Our Ref: BR/43/20/HH
Your Ref:

Town & Country Planning Act 1990 (as amended)
Town & Country Planning (Development Management Procedure) (England) Order 2015
Application for Planning Permission for Works or Extension to a Dwelling

Development Single storey rear extension
Location 93 Pevensey Road Bognor Regis

sheet 2 a of 3

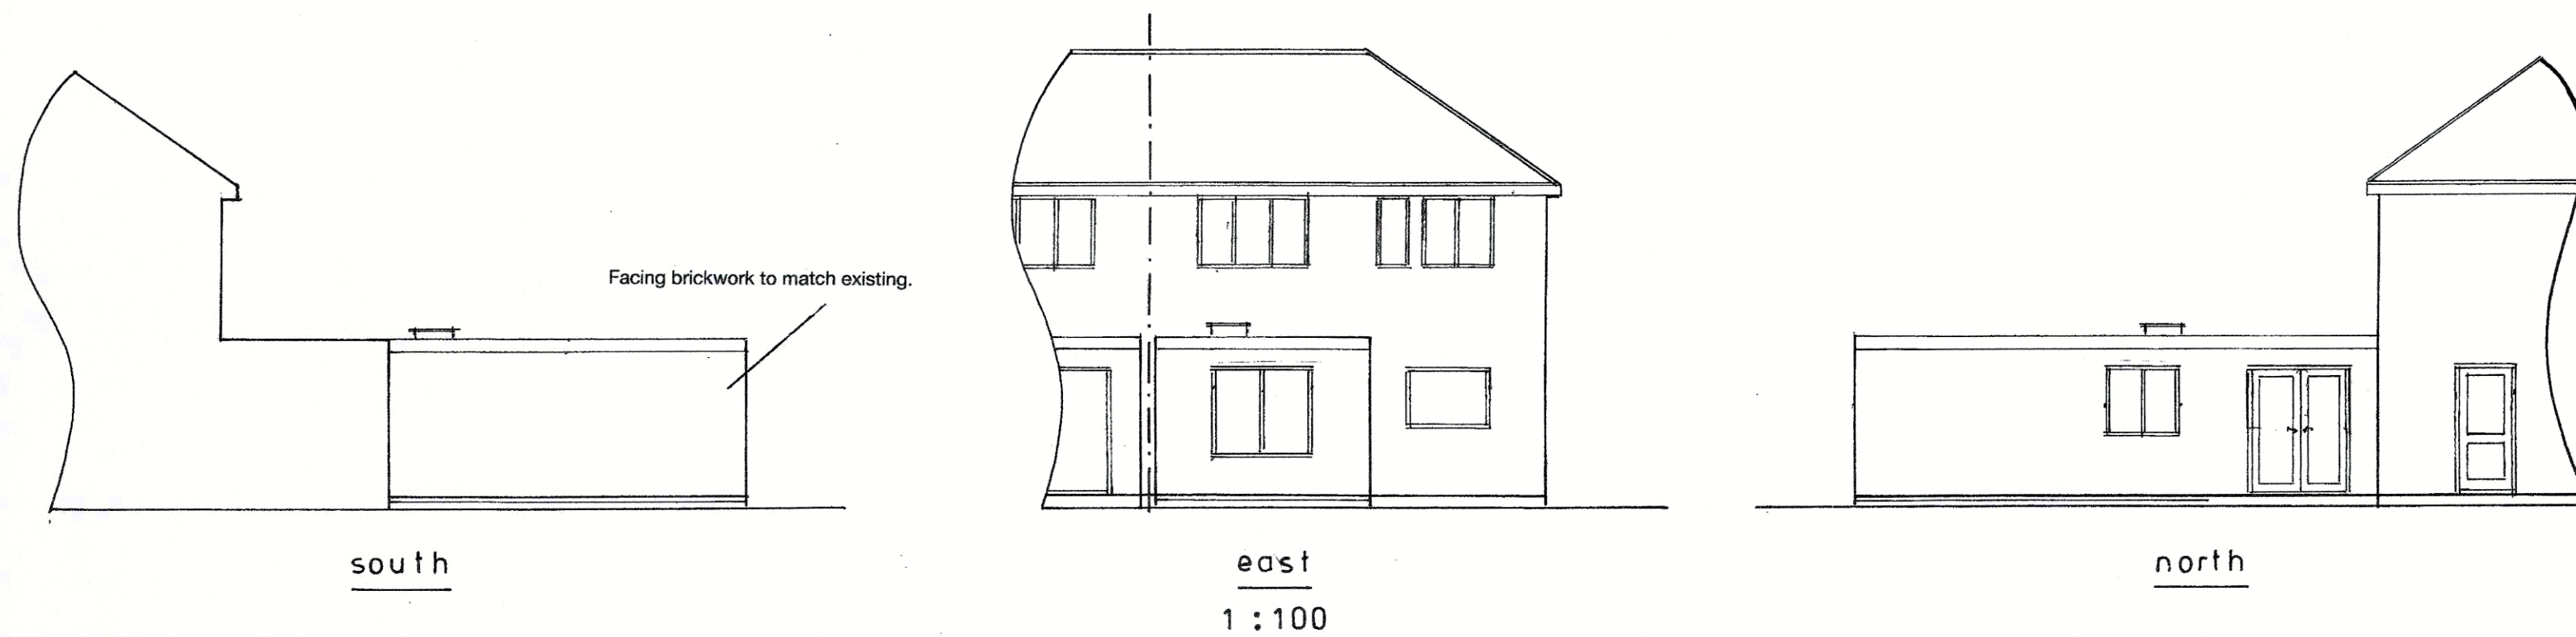
The existing and proposed elevations have been mislabelled. Please amend accordingly.
